# Screening for Environmental Impact Assessment

**Section 146B Alteration Request (ABP PA92.319013)**

## **Medite DAC Europe**

Redmondstown, Clonmel, County Tipperary

Proposed Alterations Design
Development Area 1 & 2

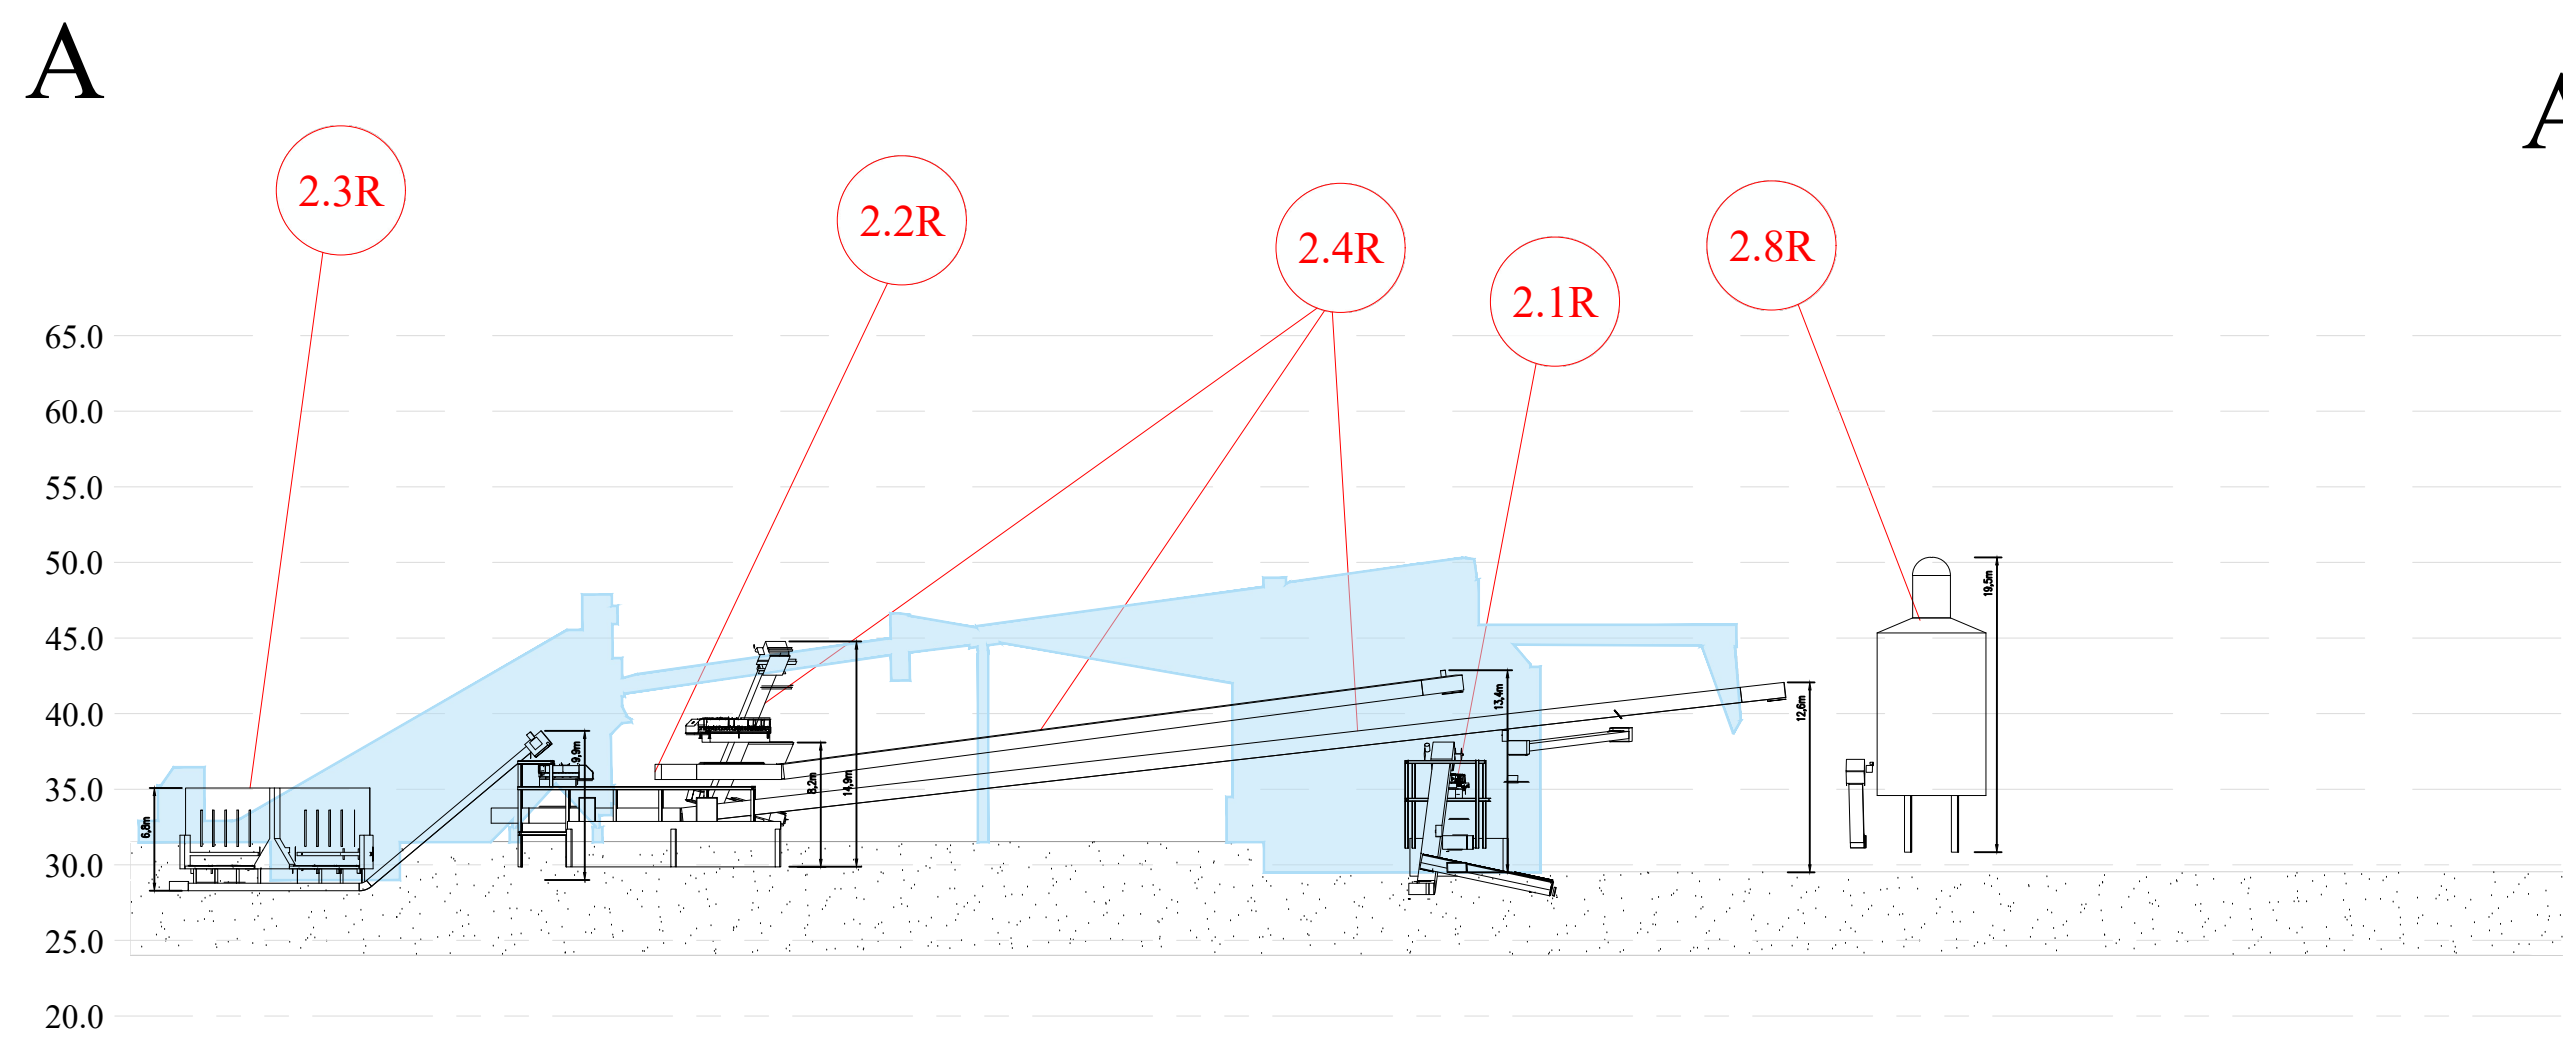
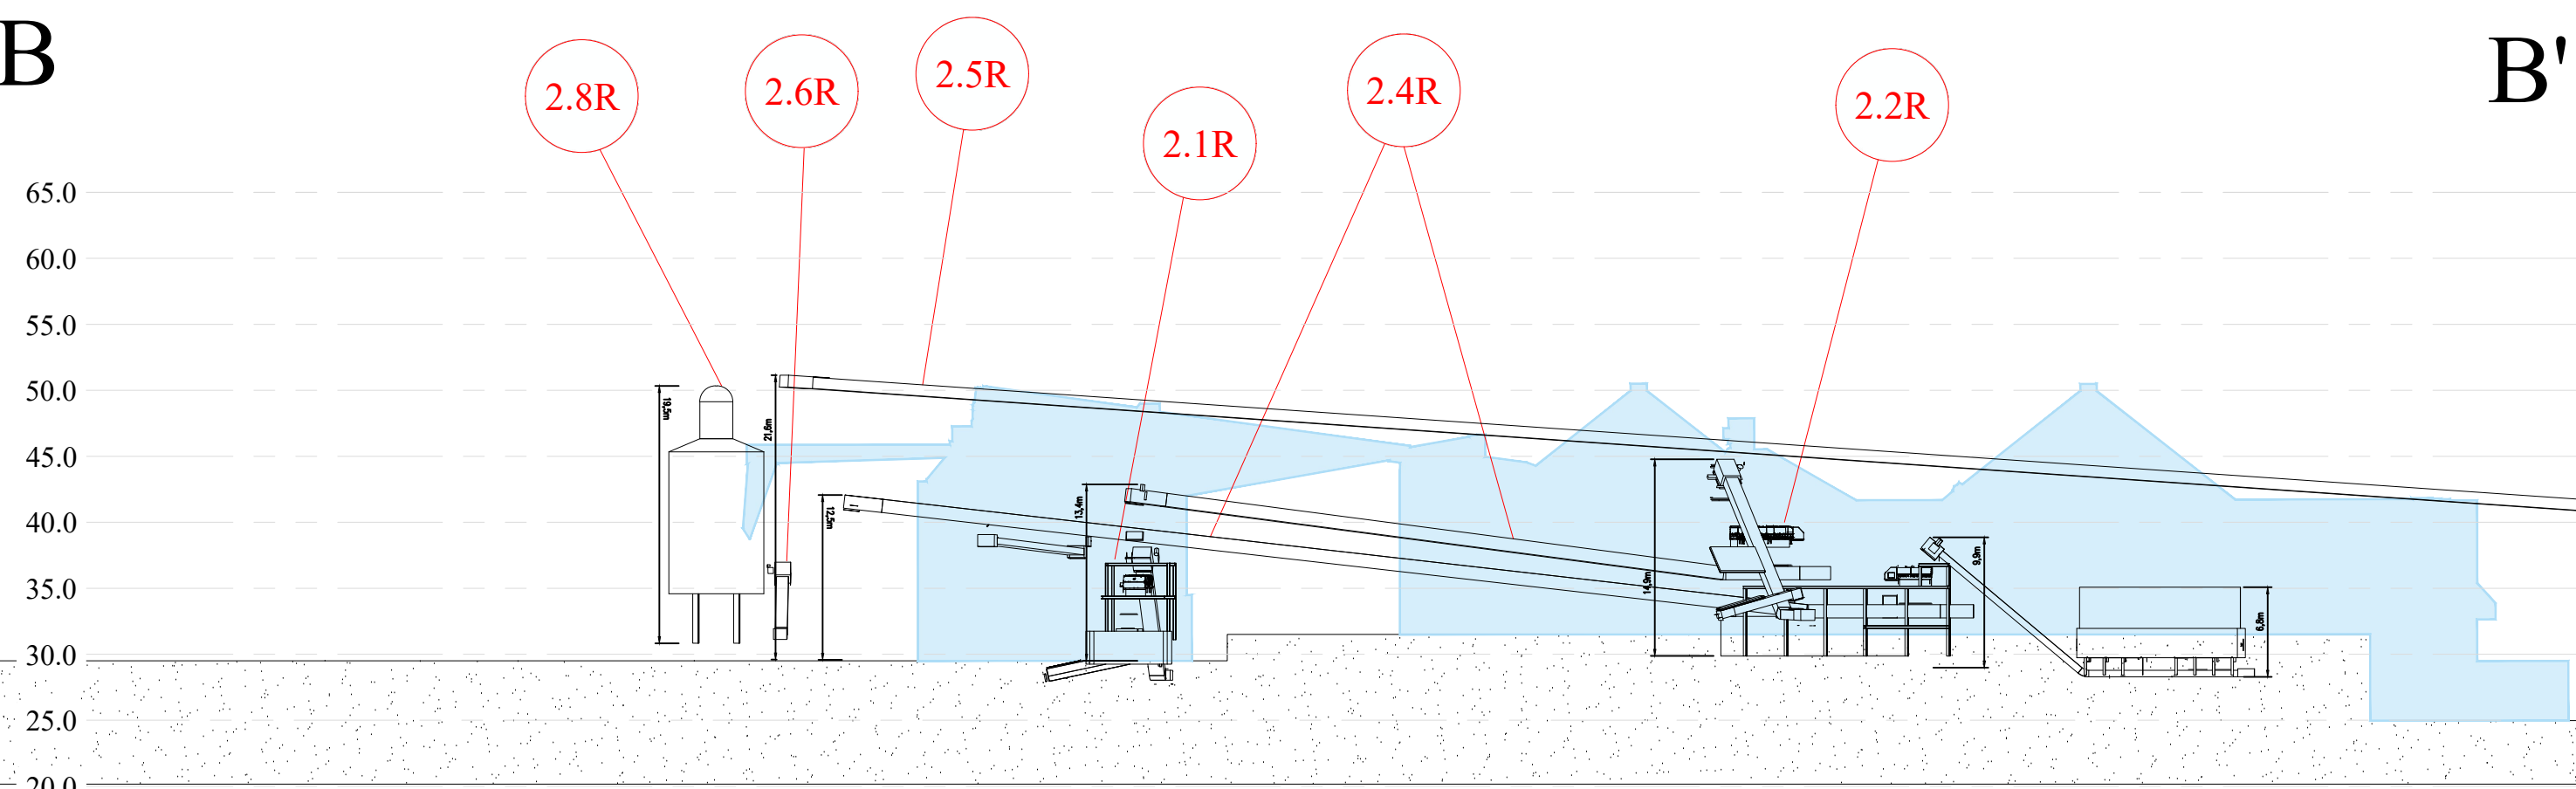
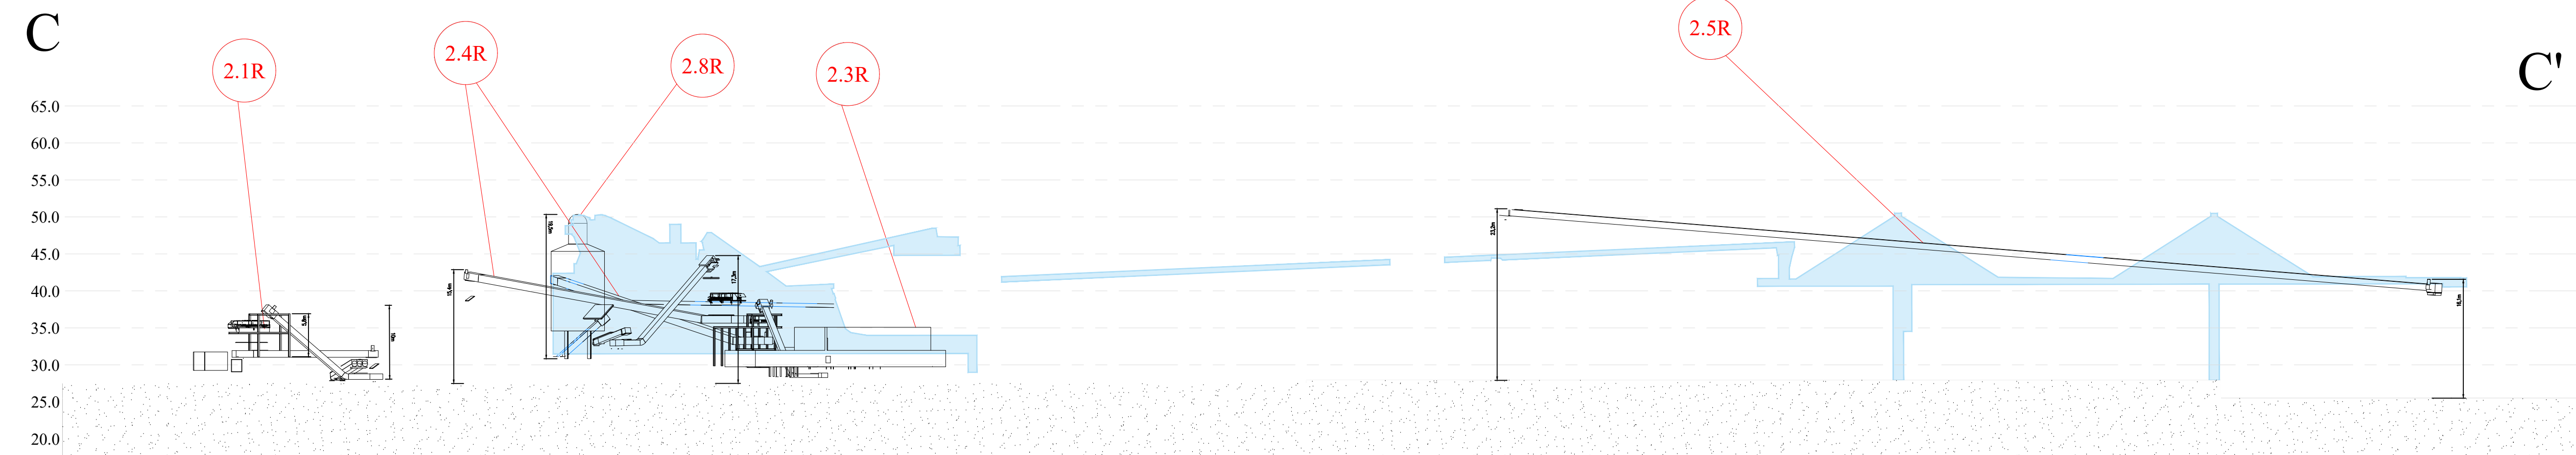
No.	Permitted Item	Description	No. (R)	Proposed Alteration Dimensions	Summary of Alterations
ITEM 2.1	1 x Fuel Reception Units 7.0m x 5.0m x 5.5mH Area = 35m <sup>2</sup>	A new Fuel Reception unit will be constructed adjacent to the existing Fuel Reception. The existing hopper that is currently in this location will be removed. The Fuel Reception Units will facilitate the unloading of HGV's delivering fuel chip to site in walking floor trailers. The HGV's will reverse the trailers into position and evacuate the walking floor trailer into the reception unit that gathers and conveys the material onwards. The units are covered to minimise any potential dust emissions.	ITEM 2.1R	Fuel Reception Units altered dimensions to 7.3m x 4.9m x 5.8mH  <b>Difference in dimensions:</b> +0.3m x -0.1m x +0.3mH	<b>Proposed Area:</b> 35.77m <sup>2</sup>  <b>Area difference:</b> slight increase in area of +0.77m <sup>2</sup>  <b>Relocated</b> to location of 7.5m northeast of permitted Fuel reception unit.

ITEM 2.2	Fuel infeed hopper 3.0m x 6.2m x 5 m H Area = 18.6m <sup>2</sup>	The Fuel infeed Hopper will facilitate the introduction of fuel wood chipped onsite into the fuel storage system by means of a front-end loader.	ITEM 2.2R	Fuel infeed hopper altered dimensions to 2.3m x 3.7m x 8.2mH  <b>Difference in dimensions:</b> -0.7m x -2.5m x +3.2mH	<b>Proposed Area:</b> 8.5m <sup>2</sup>  <b>Area difference:</b> reduction in area of -10.1m <sup>2</sup>  Realigned to match process/operational requirements and relocated to more suitable location of

No.	Permitted Item	Description	No. (R)	Proposed Alteration Dimensions	Summary of Alterations
					35.13m east of permitted Fuel infeed hopper
ITEM 2.3	Walking Floor Infeed System 24m x 18.6m x 5.0m H Area = <del>202.3</del> <sup>3</sup> 446.4m <sup>2</sup>	The Walking Floor infeed system facilitates the introduction, buffer storage, and mixing of production residue fuels into the fuel storage and conveying system by means of a front-end loader.	ITEM 2.3R	Walking Floor Infeed System altered dimensions to 27.3m x 12.2m x 6.8mH  Difference in dimensions: +3.3m x -6.4m x +1.8mH	<b>Proposed Area:</b> 333.0m <sup>2</sup>  <b>Area difference:</b> reduction in area of -113.34m <sup>2</sup>  Realigned and sized to match process/operational requirements. Relocated to more suitable location 15.7m north of permitted walking floor infeed system.

ITEM 2.4	Conveying Systems #1 (Into Storage Building) Approx 200m length of conveying Height Varies from ground to max of 20.8m, refer to drawings. Conveying System #1 Area = 520m <sup>2</sup>	The conveying systems will consist of both belt and chain conveyors (all covered to minimise dust emissions) to transport fuel from the Fuel Infeed Hopper (Item 2.3) and from the Walking Floor Infeed System into the Fuel Storage Building (Item 1.19).	ITEM 2.4R	Conveying Systems #1 (Into Storage Building) Consists of 3 lengths of conveyors of approx. length of 16.2m, 56.8m and 106.9m respectively = 179.9m length of conveying Difference in dimensions: reduced by -20.1m in length Layout streamlined to match process/operational requirements	<b>Proposed Area:</b> 207.4m <sup>2</sup>  <b>Area difference:</b> due to shorter length and reconfigure of conveyor; the area of the conveyors is reduced from 520m <sup>2</sup> to 207.4m <sup>2</sup> = Reduction in area of 312.6m <sup>2</sup>

No.	Permitted Item	Description	No. (R)	Proposed Alteration Dimensions	Summary of Alterations
ITEM 2.5	Conveying Systems #2 (from Storage Building to energy Systems)  Line 1 Energy Plant Approx 266m length of conveying Height Varies from ground to max of 22.5m, refer to drawings. Conveying System #2 Area = <del>245</del> <sup>4</sup> 295.9m <sup>2</sup>	The conveying systems will consist of both belt and chain conveyors (all covered to minimise dust emissions) to transport fuel between from the fuel storage building (item 1.19) to the respective energy systems. This will include an existing conveyor that will be relocated.	ITEM 2.5R	Conveying Systems #2 (from Storage Building to energy Systems) to ITEM 2.5 to Line 1 Energy Plant  Reduced to approx. 170m length of conveying Height Varies from ground to max of 23.2m  Difference in dimensions: length reduced by -96m due to utilising existing conveyors and slight increase of +0.7m in height	<b>Proposed Area:</b> 165.0m <sup>2</sup>  <b>Area difference:</b> due to utilising existing of conveyor; the area of the conveyors is reduced from 295.9m <sup>2</sup> to 165.0m <sup>2</sup> = Reduction in area of – 130.9m <sup>2</sup>  Conveyor alignment altered from refiner building to energy plant

ITEM 2.6	Line 2 Energy Plant Approx 44m length of conveying Height Varies from ground to max of 20.9m, refer to drawings.  Conveying System #2 Area = 77.5m <sup>2</sup>	The conveying systems will consist of both belt and chain conveyors (all covered to minimise dust emissions) to transport fuel between from the fuel storage building (item 1.19) to the respective energy systems. This will include an existing conveyor that will be relocated.	ITEM 2.6R	Line 2 Energy Plant  Approx 10m length of conveying Height Varies from ground to max of 11.0m  Conveying System #2  Difference in dimensions: reduction of -33.0m in length and -9.9m in height	<b>Proposed Area:</b> 11.0m <sup>2</sup>  <b>Area difference:</b> the area will be reduced by -66.5m <sup>2</sup>  Conveying Systems #2 (from Storage Building to energy Systems) re-configured and utilise existing conveyors.

No.	Permitted Item	Description	No. (R)	Proposed Alteration Dimensions	Summary of Alterations
	<p>#1 Length = 161.5m x Ø150mm pipe</p> <p>#2 Length = 202.9m x Ø150mm pipe</p> <p>Total length = 364.4m</p>	<p>some alterations and additions to facilitate the proposed development.</p> <p>The existing Line 2 Sander Dust &amp; Saw Dust pneumatic extraction systems will be modified to provide separate systems for sander dust and saw dust. This will incorporate additional pneumatic conveying plant and infrastructure to transport the saw dust to the existing sander dust silos. A new Sander Dust Silo Ø=6.0M x H=16M &amp; associated filter plant (Item 3.7) will be located in Development Area 2, adjacent to the proposed Line 1 Energy System. The Sander Dust Silo will receive pneumatically conveyed fuel dust from the existing on sander dust silos and will discharge material into the Line 1 Energy Plant as fuel.</p> <p>The existing Line 1 Saw Dust pneumatic extraction system will be modified to send the saw dust to either (by means of a divert gate) the proposed Edge Trim Silo (see above) Or the proposed Sander Dust Silo (also see above).</p> <p>The existing Line 1 Sander Dust Silos (2No.) discharges will be modified to deliver sander dust to the new Sander dust silo proposed adjacent to the proposed Line 1 Energy System. The Ø150mm pipe that currently connects the existing Line 1 Sander Dust Silos to the existing Line 1 Energy System will be redirected to the proposed new sander dust silo.</p>	ITEM 2.7R	<p>Item 2.7 Pneumatic Transport Ducts</p> <p>#1 Length = 161.5m x Ø150mm pipe</p> <p>#2 Length = 257.2 m x Ø150mm pipe</p> <p><b>Difference in dimensions:</b> #2 Length has increased by +54.3m to align with Item 3.8R Line 1 Thermal Fluid Pipping</p>	<p><b>Proposed Length: 418.7m</b></p> <p><b>Length difference: an increase of +54.3m</b></p>

No.	Permitted Item	Description	No. (R)	Proposed Alteration Dimensions	Summary of Alterations
ITEM 2.8	Edge Trim Silo Ø=5.6m x H= 19.5m Area = 6.2m x 6.2m = 38.4m <sup>2</sup>	The existing Edge Trim System will be modified by dismantling and removing the existing Edge Trim Silo and associated filter plant (Item 1.26) (Air Emission A2-20) and constructing a new Edge Trim Silo Ø=5.6m x H= 19.5m, (Item 2.8) and associated filter plant adjacent to the fuel storage building. The Ø150mm pipe that currently connects the production process to the existing Edge Trim Silo will be redirected to the new Edge Trim Silo (Item 2.7). The discharge system within the new Edge Trim Silo will deposit the material into the fuel storage system conveyors. The alterations will include the pneumatic conveying plant and infrastructure to transport the edge trim to the new silo and the silo discharge system to deposit the material into the fuel storage system conveyors.	ITEM 2.8R	Edge Trim Silo Ø=7.2m x H= 19.5m  Difference in dimensions: +0.4m x 0mH	<b>Proposed Area:</b> 51.8m <sup>2</sup>  <b>Area difference:</b> an increase of +13.4m <sup>2</sup>  Relocated to more suitable location of 37.3m east of permitted Item 2.8 Edge Trim Silo
